Rezoning Transportation Analysis

Petition Number: 2021-169

General Location Identifier: 03111235

Date	Description
11-19-2021	First Review (KP)
12-20-2021	Second Review (KP)

JOB NO.	99999
SHEET NO.	RZ-100

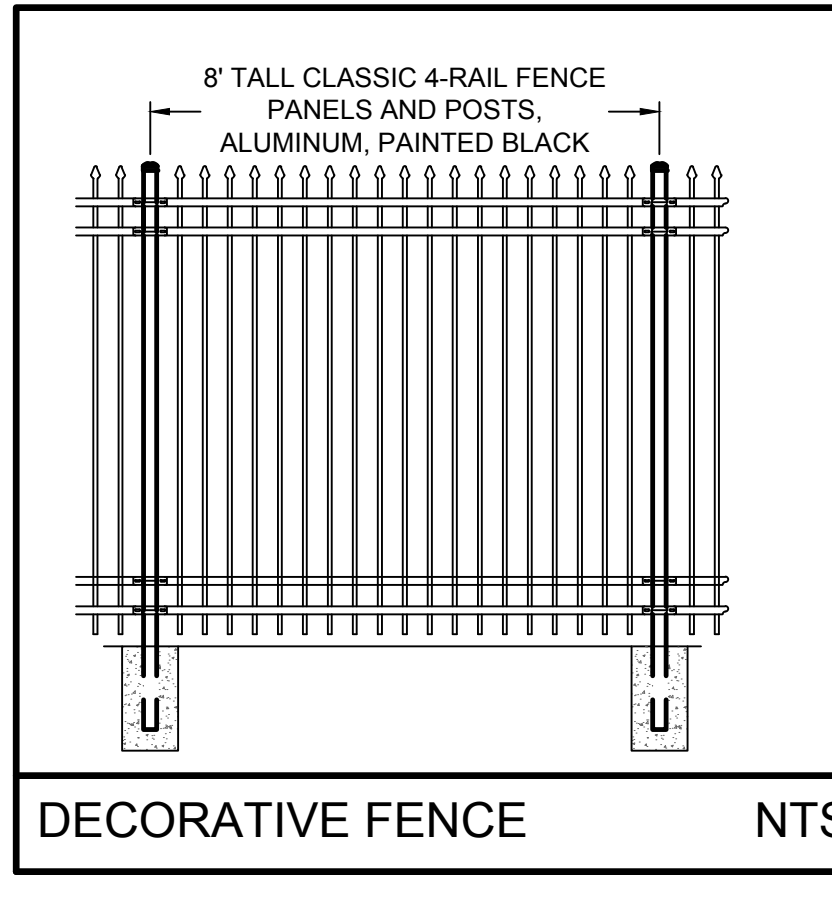
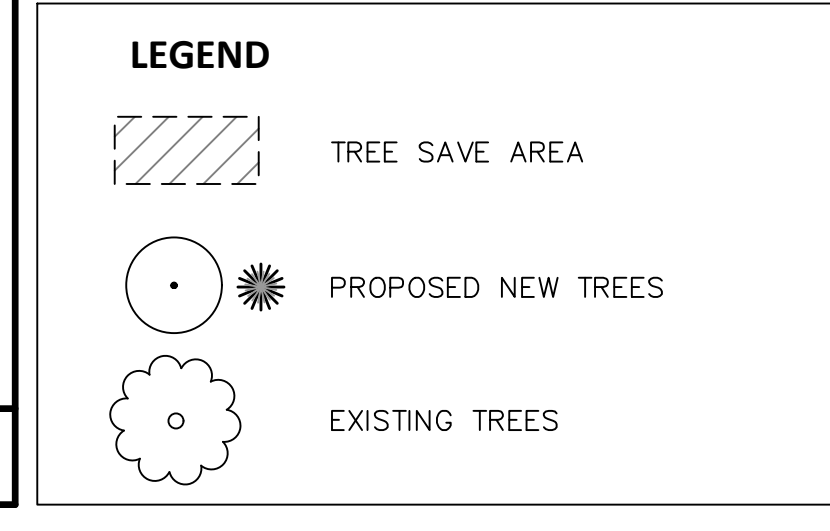
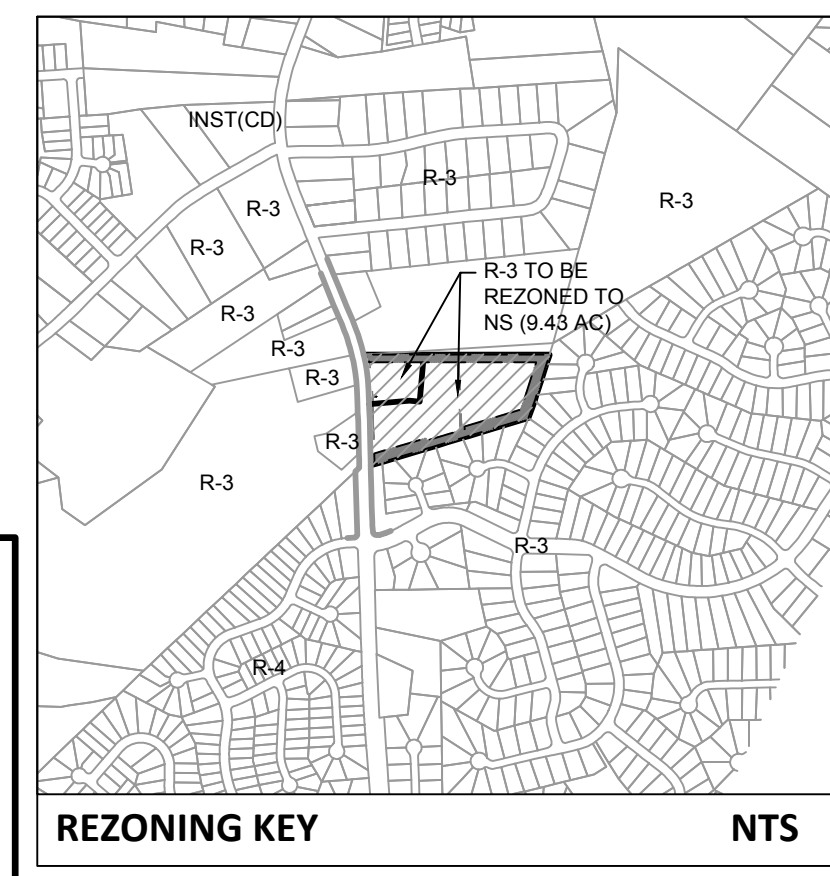
3. Revise site plan and conditional note(s) to commit to dedicate 52-feet of right-of-way from the existing centerline of Mount Holly-Huntersville Road. The site plan shall label and dimension the right-of-way from the road centerline.
